Jeffrey Peng
Department of Planning, Housing and Infrastructure
Major Projects Portal

State Environmental Planning Policy (Transport and Infrastructure) 2021
State Significant Development Application - SSD-63168959
269 Lane Cove Road, Macquarie Park
Request for additional information

9 September 2024

METRO ADJACENT FOOTING PLAN
SCALE: 1:200

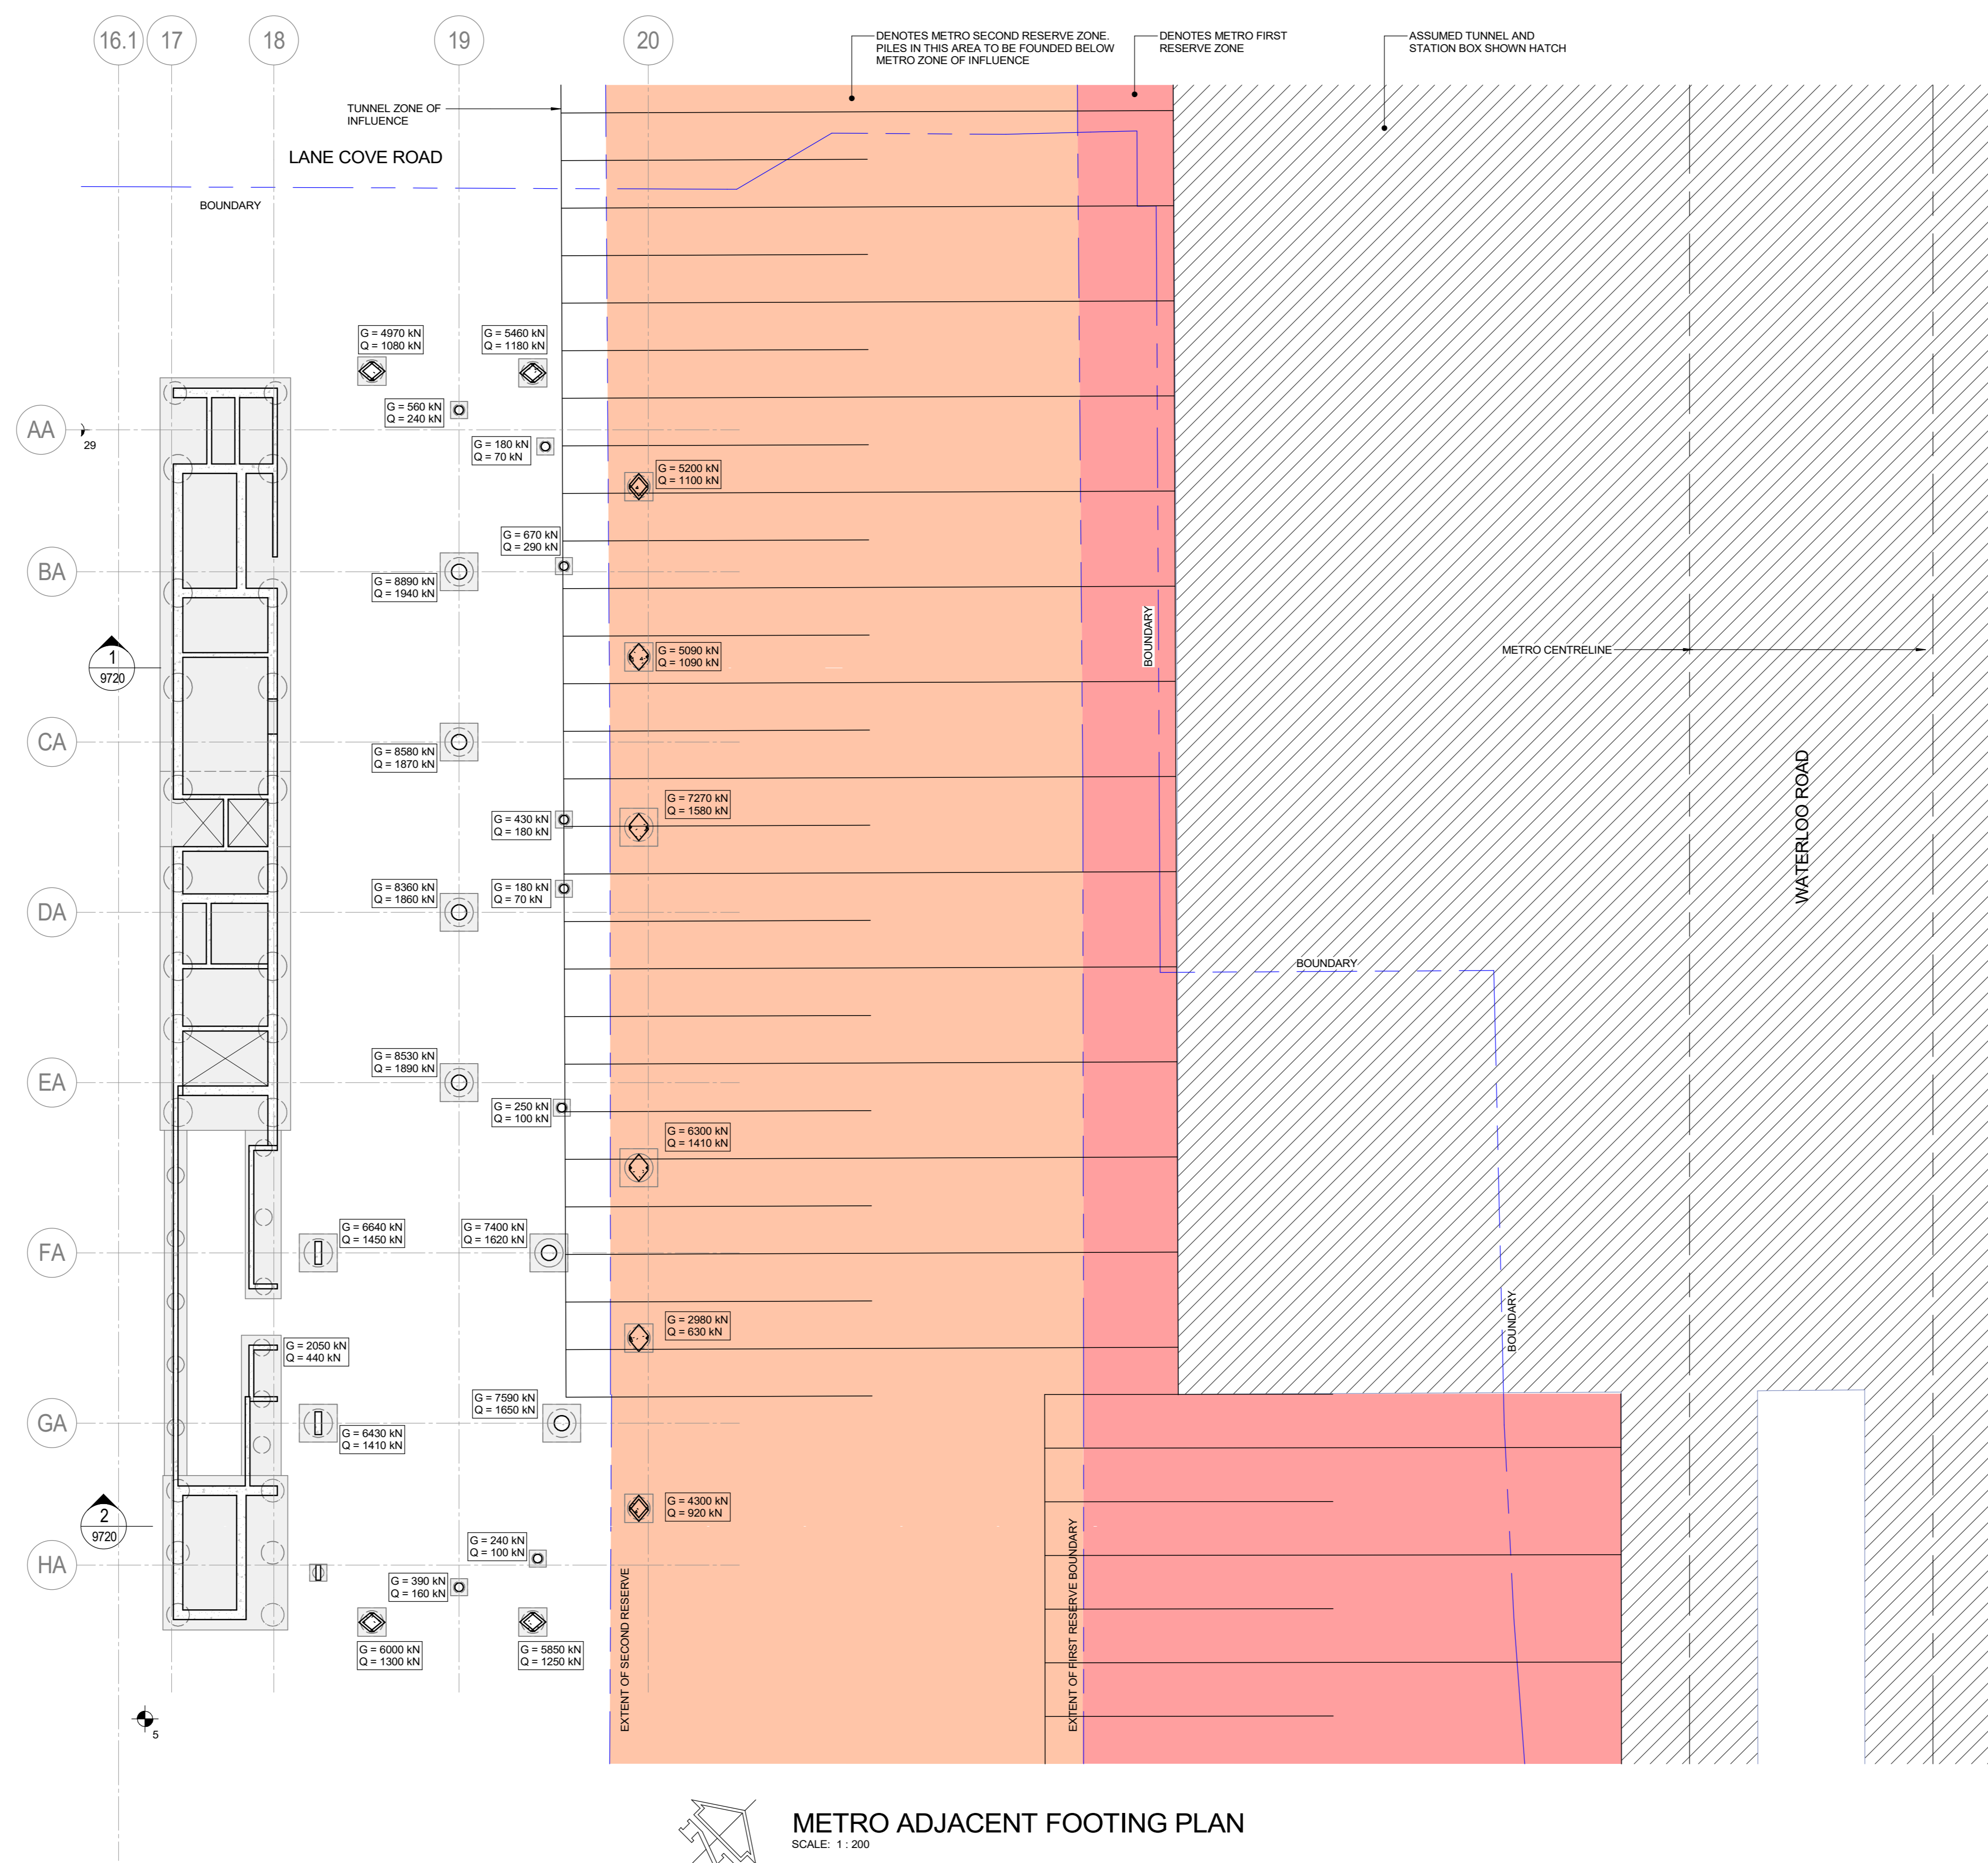
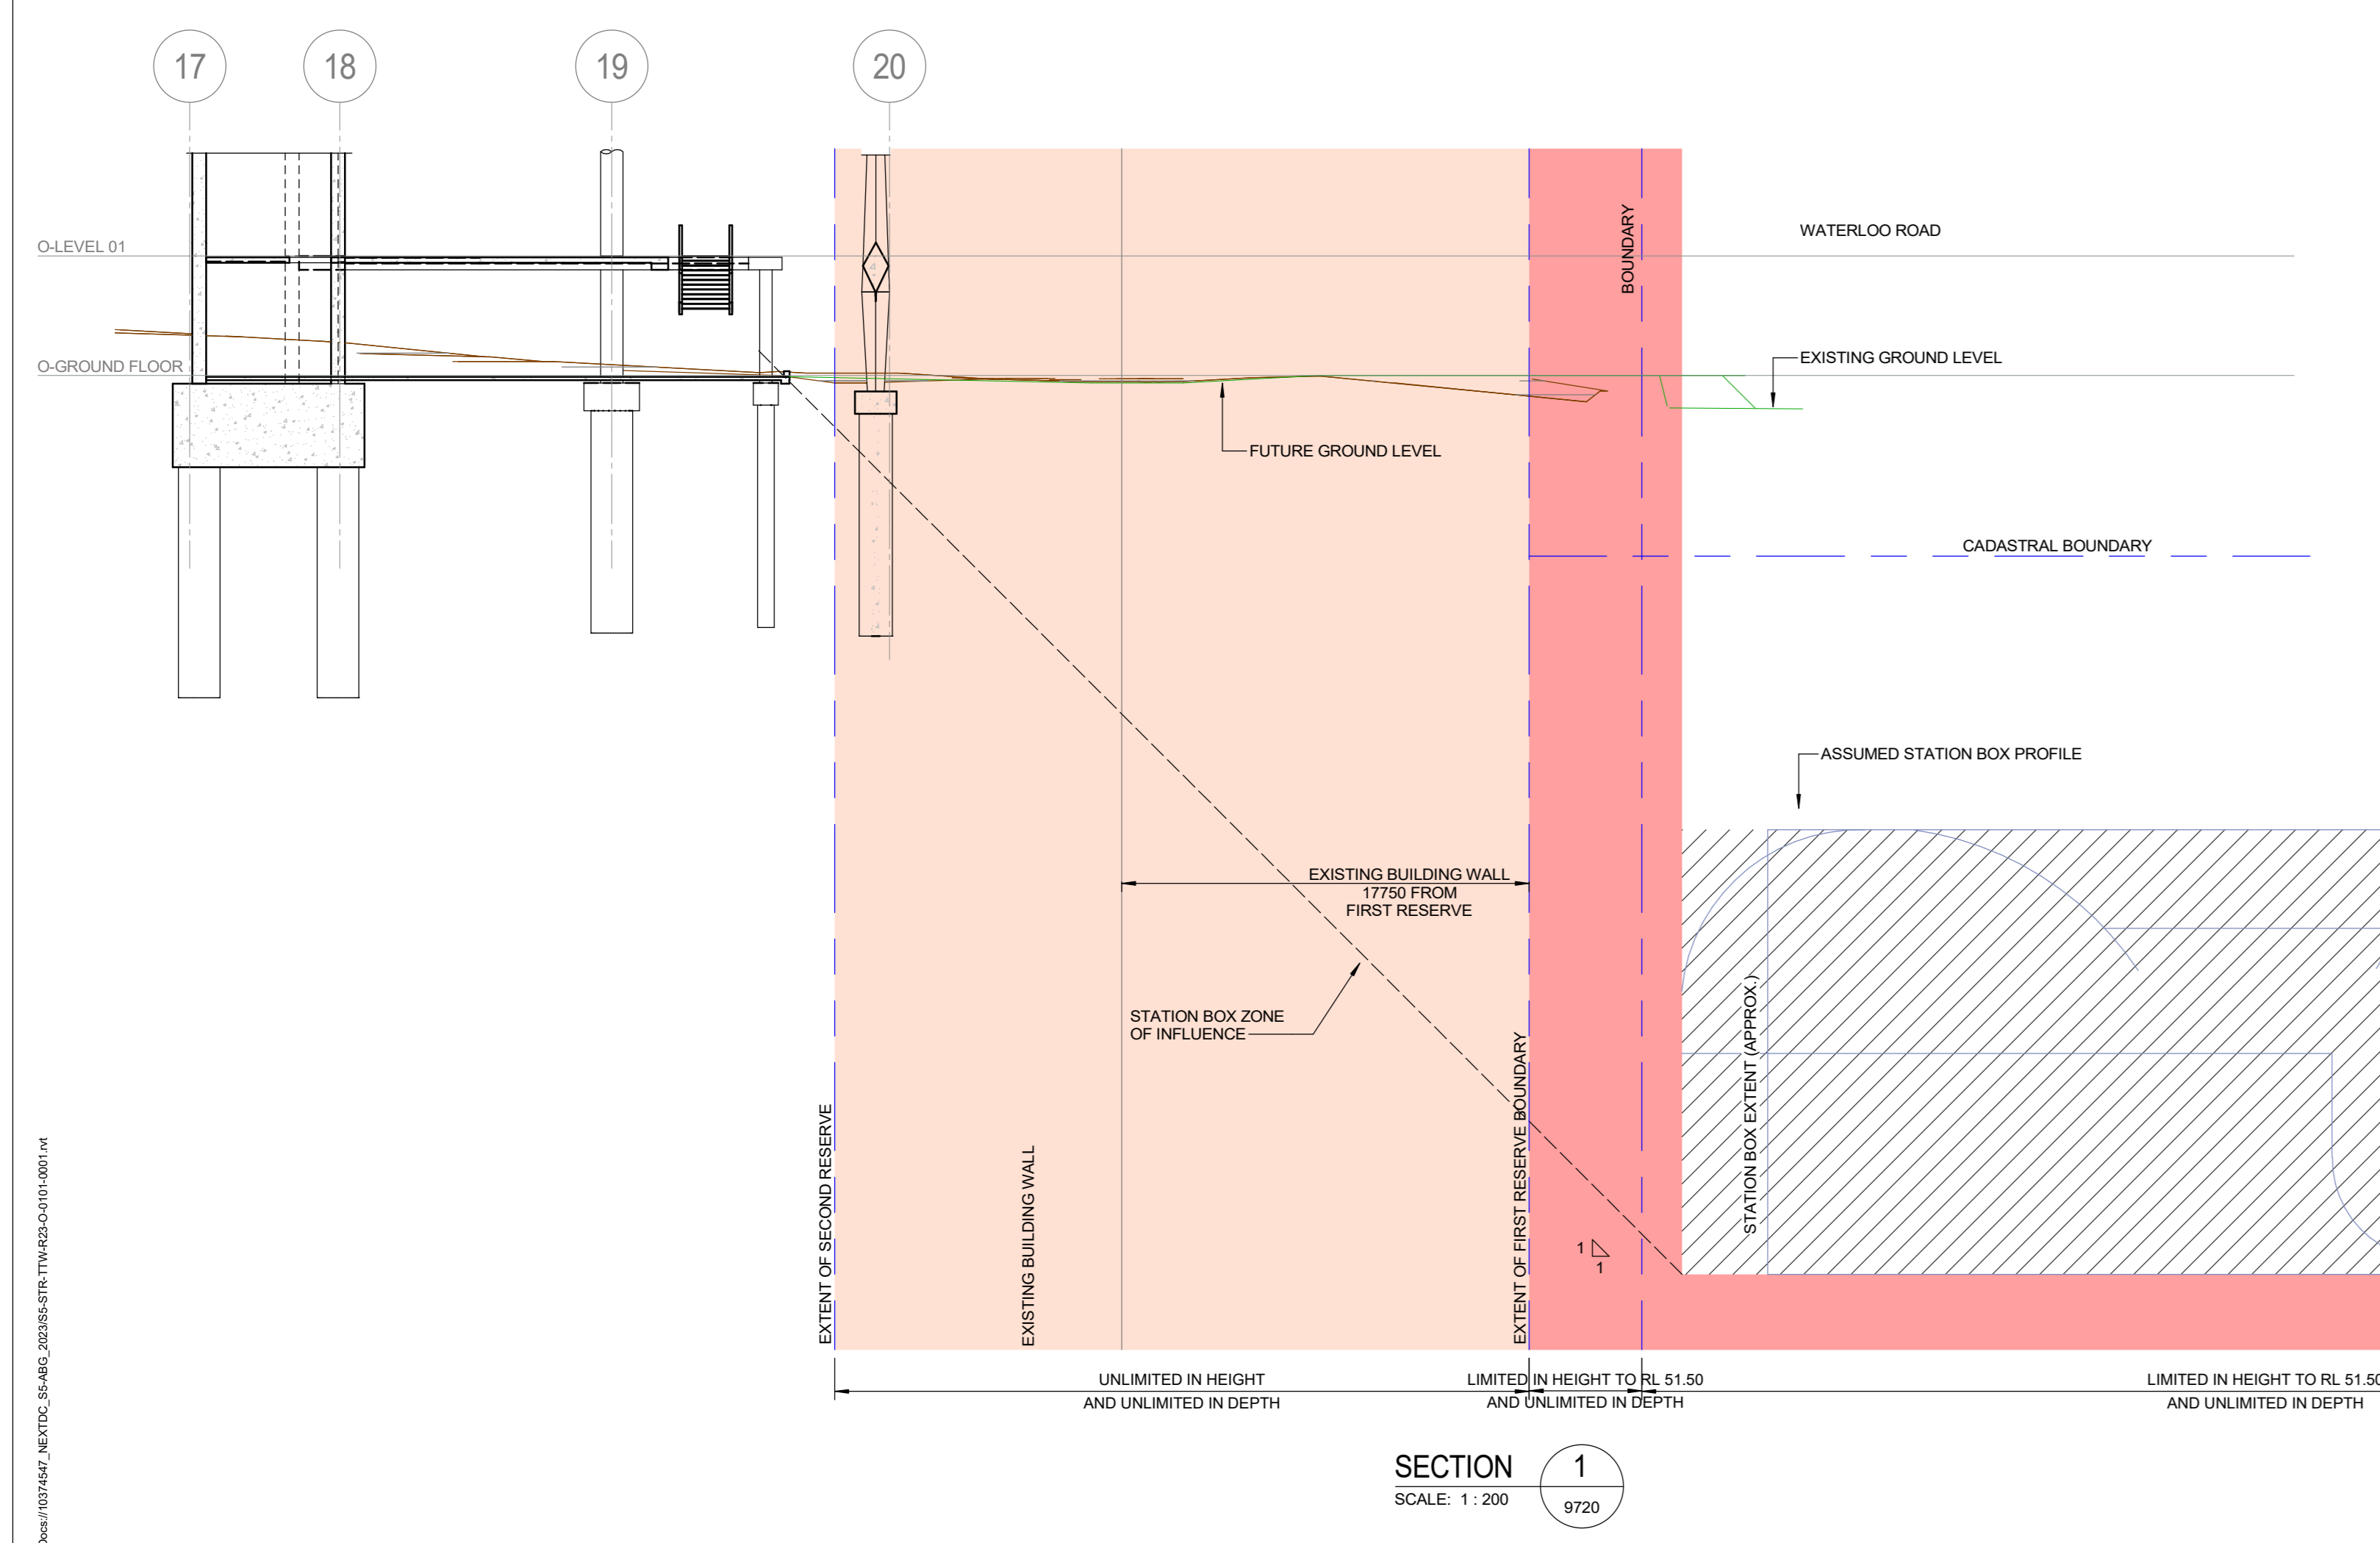
- a) A detailed survey plan showing the relationship of the proposed development with respect to the rail corridor and rail infrastructure.
- b) Cross sectional drawings showing ground surface, rail tracks, sub soil profile, proposed basement excavation and structural design of sub ground support adjacent to the rail corridor. All measurements must be verified by a registered surveyor.

- e) Structural design documentation for the development which demonstrates that:
 - i) the foundation design ensures that all loads from the development are transferred and have no adverse impacts on the rail corridor, rail infrastructure or rail easements;

- iii) any deformation induced by bulk excavation will not have adverse impacts on the rail corridor, rail infrastructure or rail easements.
- f) The construction methodology for the development, including details of the structural support to be provided to the development and rail corridor during excavation and operation of the development. The construction methodology must not propose any rock anchors/bolts (whether temporary or permanent) within Sydney Metro's land or easements during construction or operation of the development unless the Applicant has obtained prior written consent from Sydney Metro.
